# CITY OF ALBUQUERQUE

May 24, 2022

**Re: Champion Xpress Car Wash**  
**9640 Universe Blvd NW**  
**Traffic Circulation Layout**  
Engineer's Stamp 05-20-2022 (B10-D003J)

Drawing file: B10D003J / B10D003J_Markup_Comments.pdf

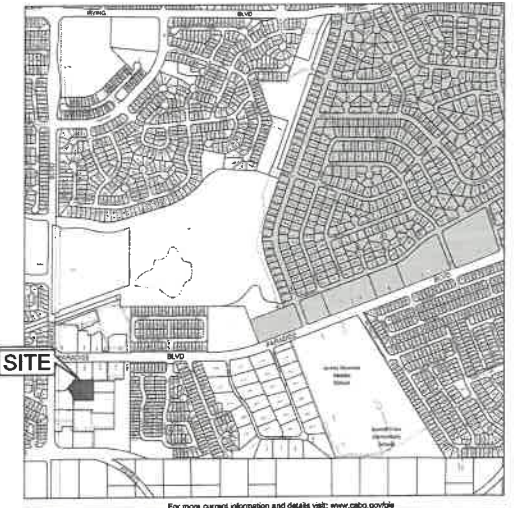
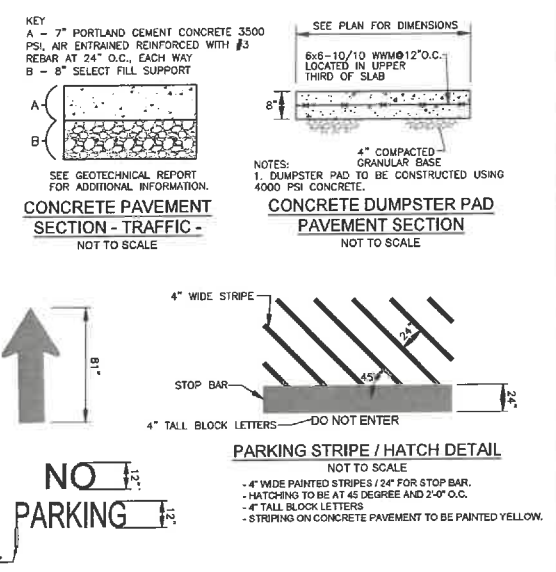
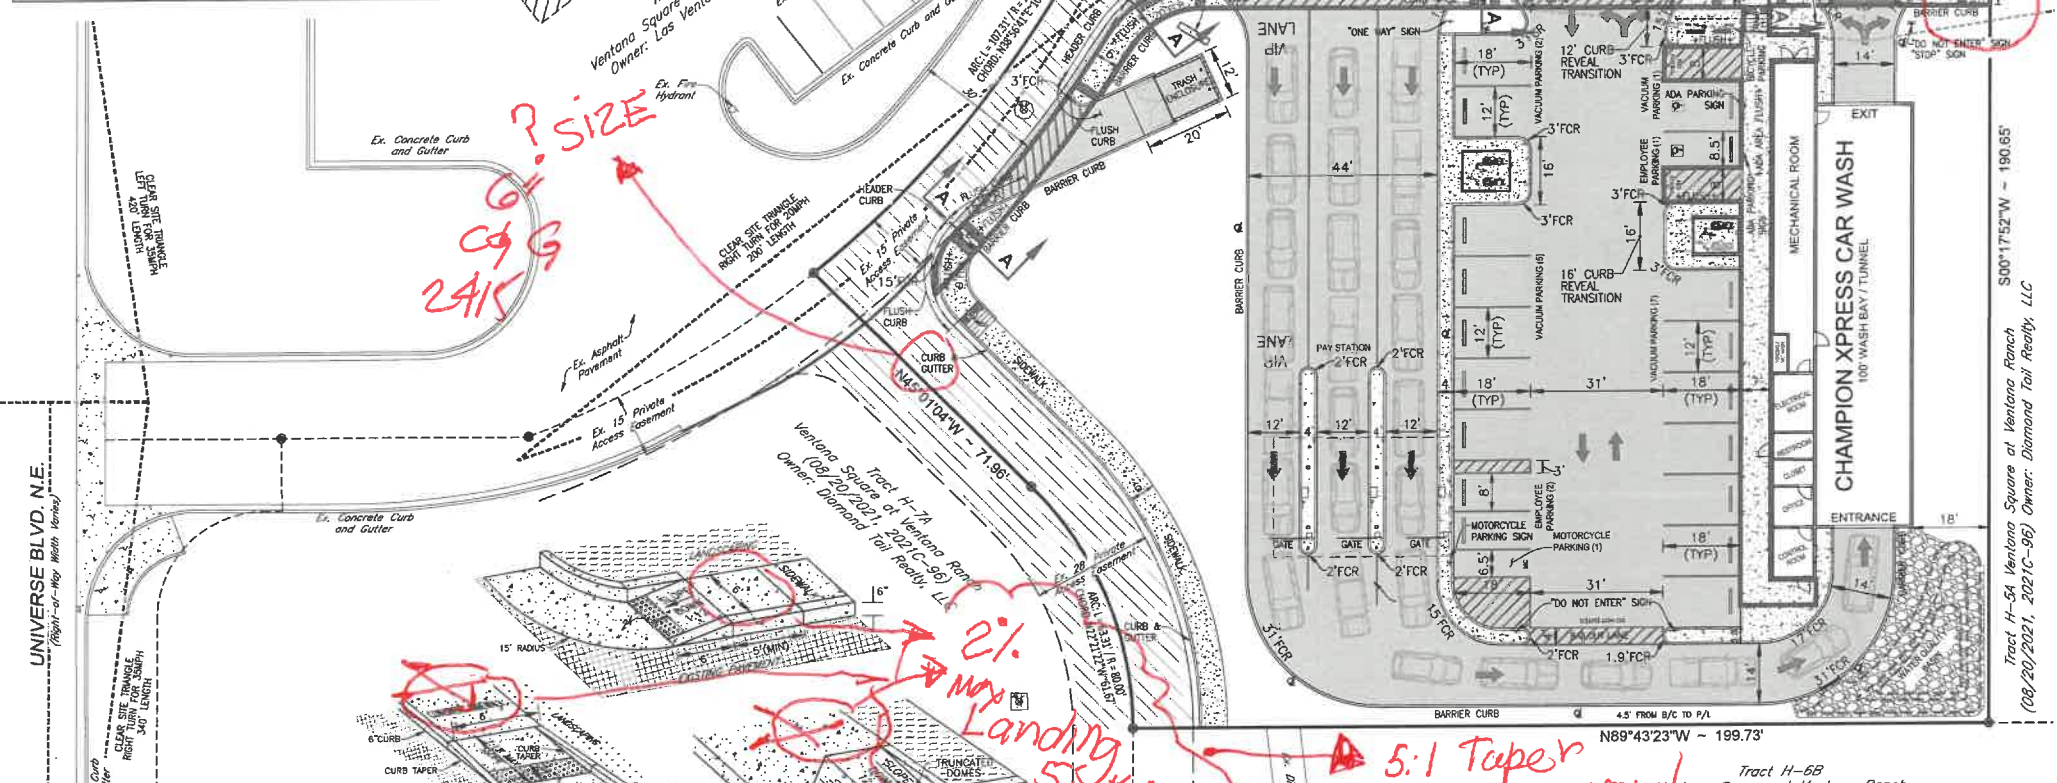
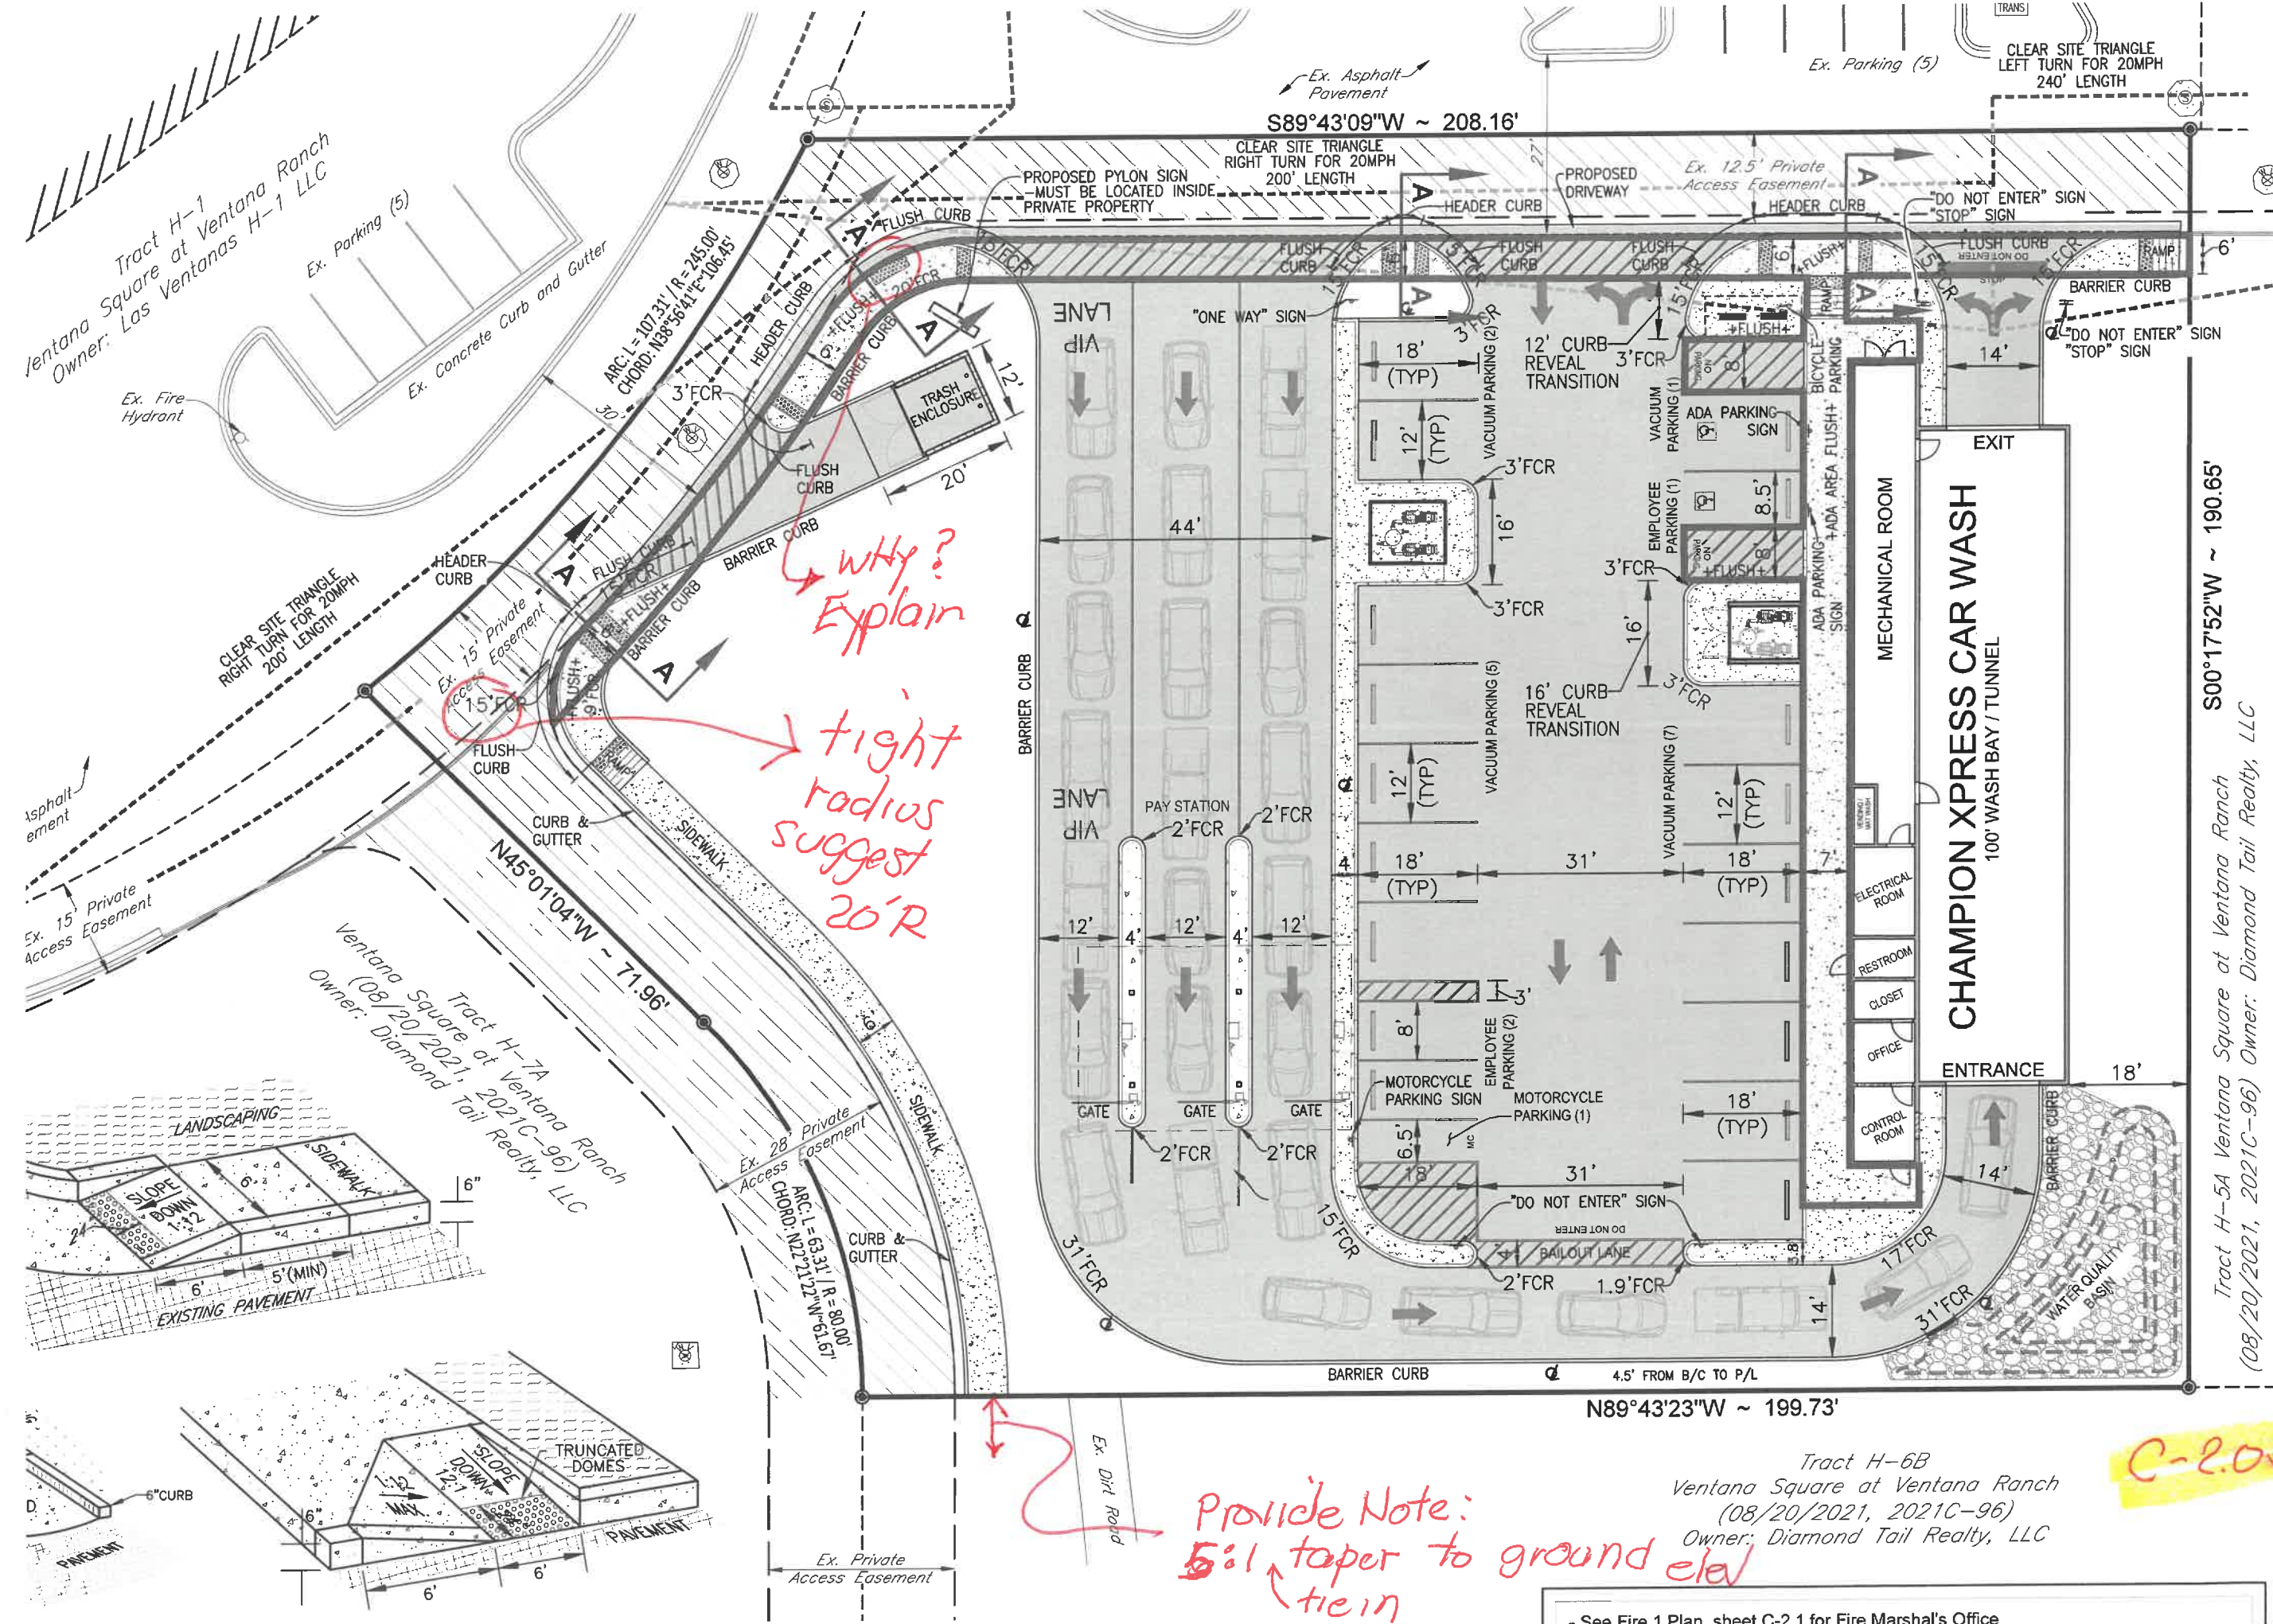
**2. Proposed ADA ramps for Site (see attachments):**

- Provide cross slopes (2% max) for landings (5'x5') on all ramps adjacent to 12:1 max. taper.
- **Section A-A:** Provide cross slopes (2% max) for landings (5'x5') on all ramps adjacent to 12:1 max. taper.
- *Truncated domes is being shown on ramp to cross 15ft private Access Easement. Why? K, then I suggest a request to complete sidewalk and ramp fronting Blakes property to connect to this ramp with domes being proposed. This is just a suggestion not a requirement.*

**3. 28 ft Private Access Easement (see attachments):**

- **Proposed c&g:** Provide note specifying 6" c&g per COA std dwg 2415 for all c&g fronting all access easements fronting proposed site development plan.
- **A note will need added at end of sidewalk:** Provide 5:1 tie in taper to ground elevations.
- **Corner radius:** Suggest a 20ft radius instead of 15ft( slightly tight) and/or provide a turning templates (delivery vehicle) to substantiate the proposed 15ft raduis.
